**JUSTINIAN HOUSE REDEVELOPMENT - MEDICAL RESEARCH FACILITY (MP 07\_0102) –  
RESPONSE TO SUBMISSIONS**

## Justinian House redevelopment for a Medical Research Facility – Environmental Assessment Report for Part 3A Project Application

**COMPARISON OF
 EXISTING & PROPOSED
 ELEVATIONS**
 drawing title

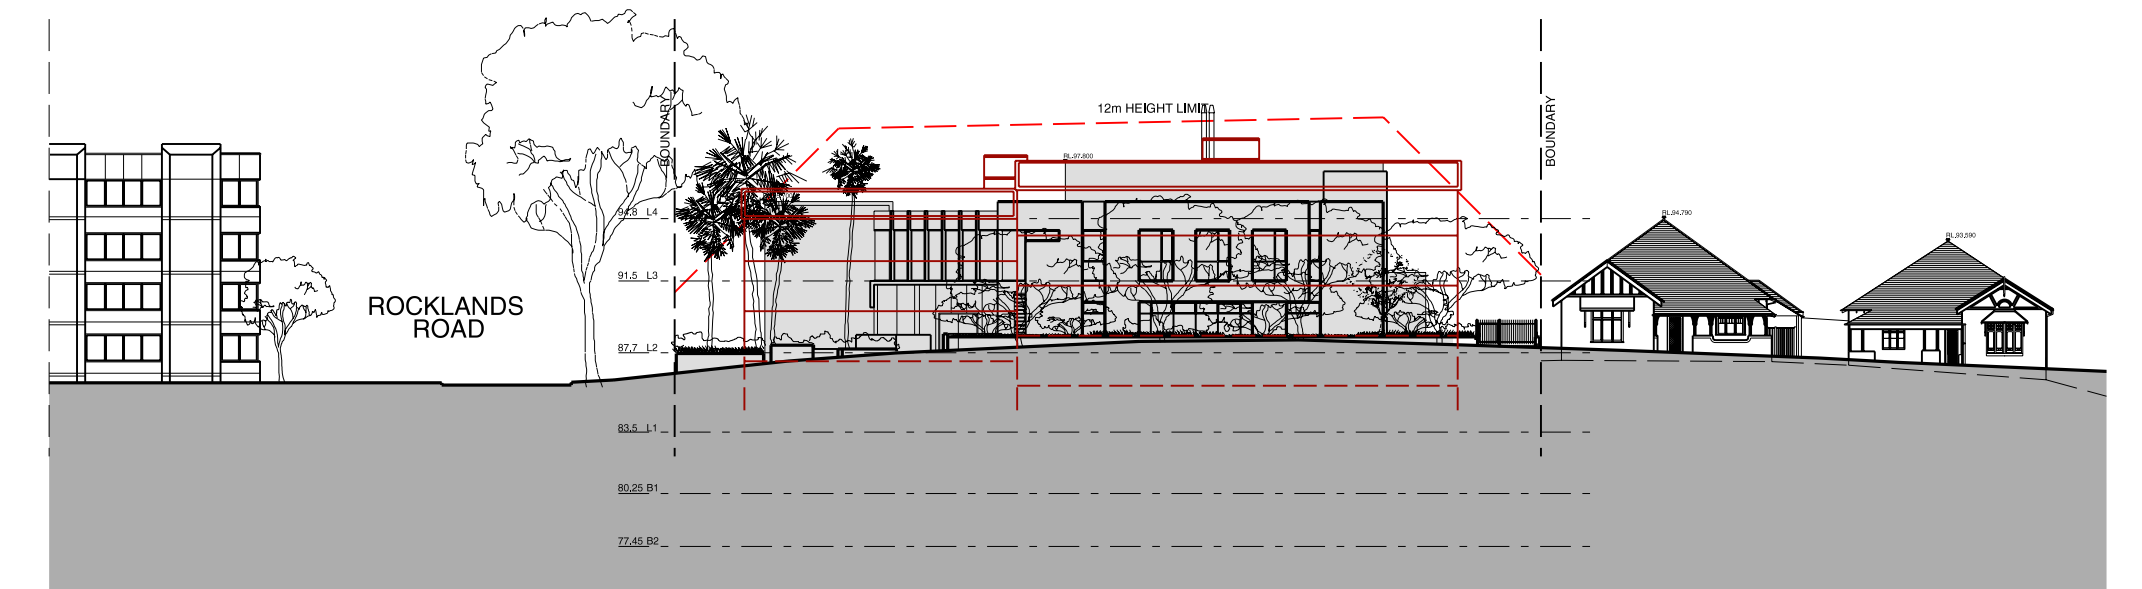
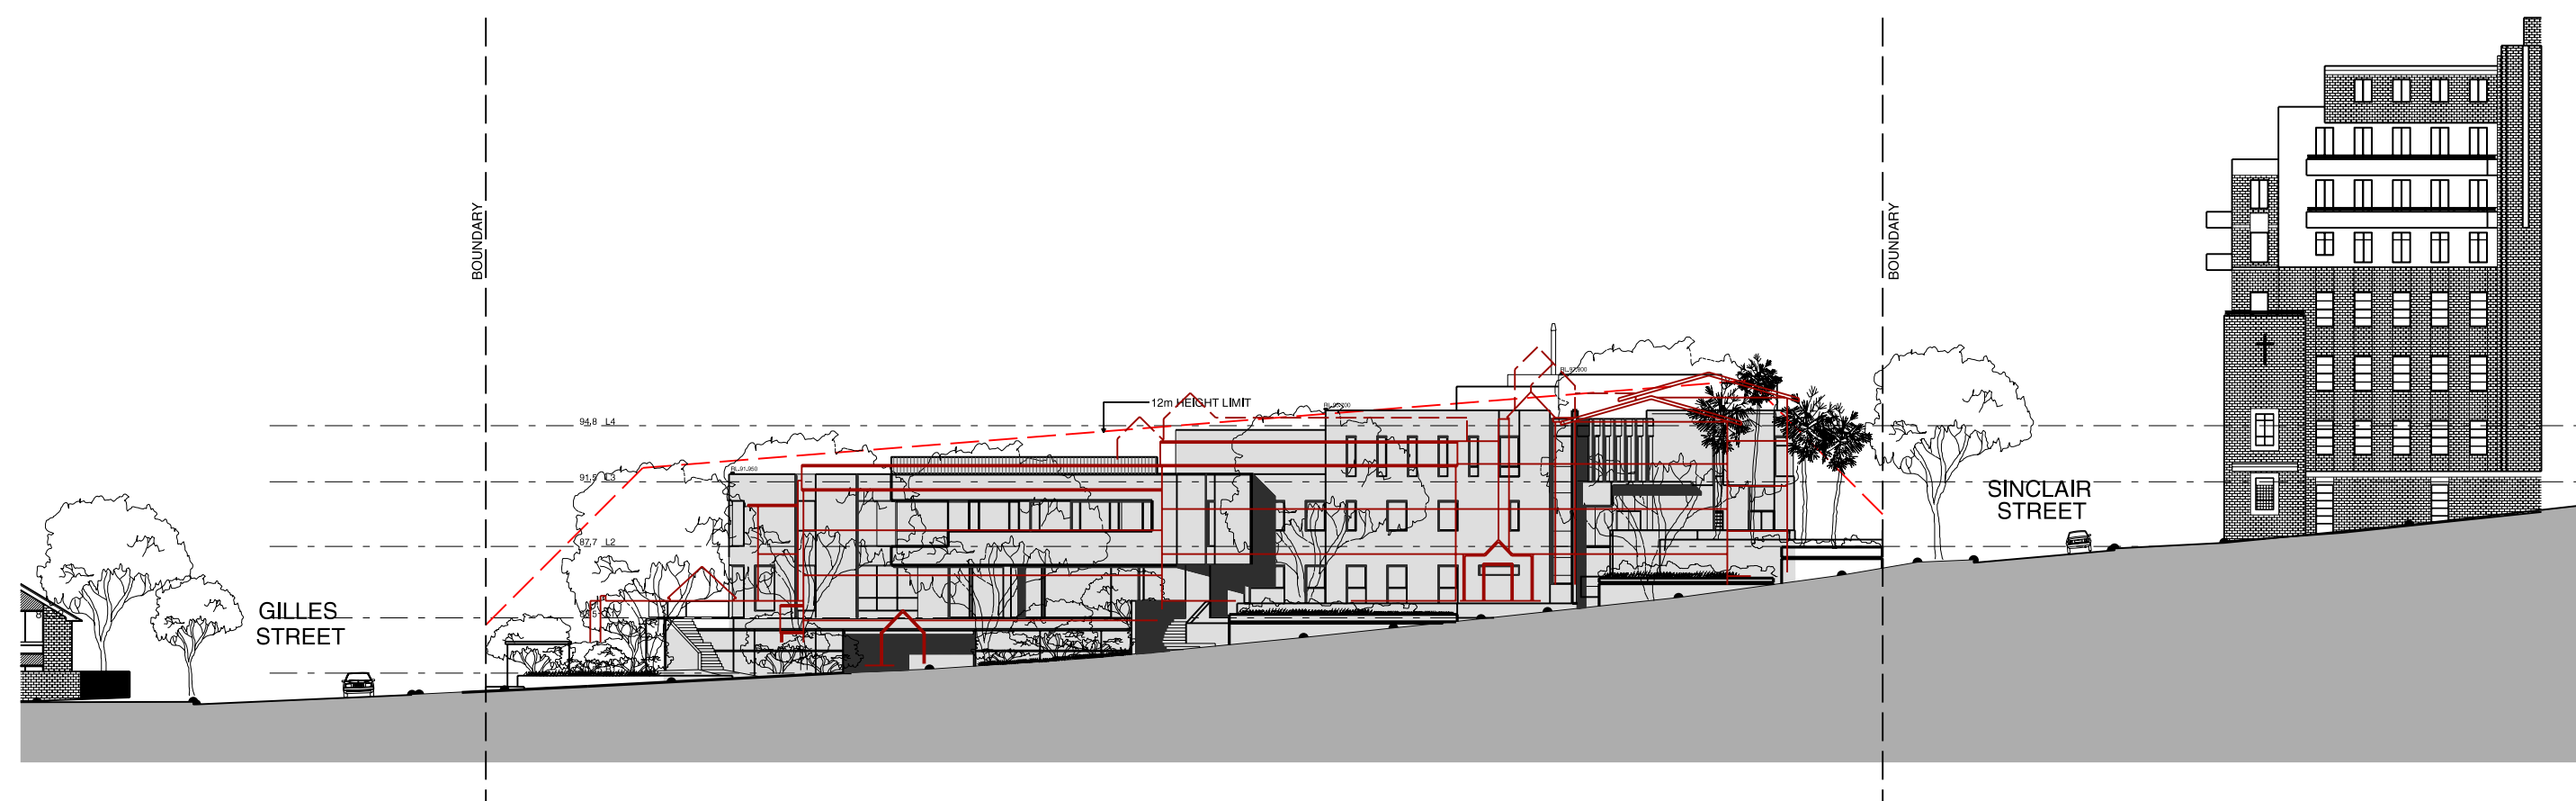
One submitter raised concerns as to the height of the proposed development on the Gillies Street frontage, when compared to the existing development.

Issue	Comment
<p>» Gillies Street frontage – impact on privacy from terrace and windows</p>	<p>The proposed development is setback further from Gillies Street than the existing development, with the first built element being the terrace wall of the carpark which is 6m from the Gillies Street boundary. The existing pool enclosure was located at the Gillies Street frontage, with a roof terrace over the chapel approx 3-5m from the boundary. The proposed new terrace is approx 9m from the boundary and 1m lower than the roof terrace of Justinian House. These windows also range from 9-11m from the boundary. Landscaping the Gillies Street frontage will include planting at lower levels and along the edge of the terrace to screen views across Gillies Street. Due to the width of Gillies Street, the proposed development is 30m from the properties on the opposite side of Gillies Street.</p>
<p>» Development is higher at Gillies Street frontage than currently</p>	<p>The overall height of the development is no higher than the ridge levels of the existing Justinian House and is substantially lower on the actual boundary alignment. The proposed development approximately projects up to 5m further to the west along Gillies Street, but it is setback further by up to 3 m along the same frontage. The additional projection is offset by the elimination of the bulk of the existing chapel. The overall height of the building along the Gillies Street frontage is completely within the allowable LEP envelope controls.</p>

The overall height of the development is no higher than the ridge levels of the existing Justinian house and is substantially lower on the actual Gillies Street frontage. Although the proposed development projects approximately 5 metres further to the west along part of the Gillies Street frontage, it is setback further from the boundary by a up to an additional 3 metres on other parts of the Gillies Street frontage. The additional projection is offset by the elimination of the bulk of the chapel in the existing development at lower levels of the medical research facility.

It should also be noted that the overall height of the building along the Gillies Street frontage is completely within the allowable North Sydney LEP building height and building height plane controls; this is shown in the massing diagram on page 11 of the Architectural Design Statement at **Appendix C** to the EAR.
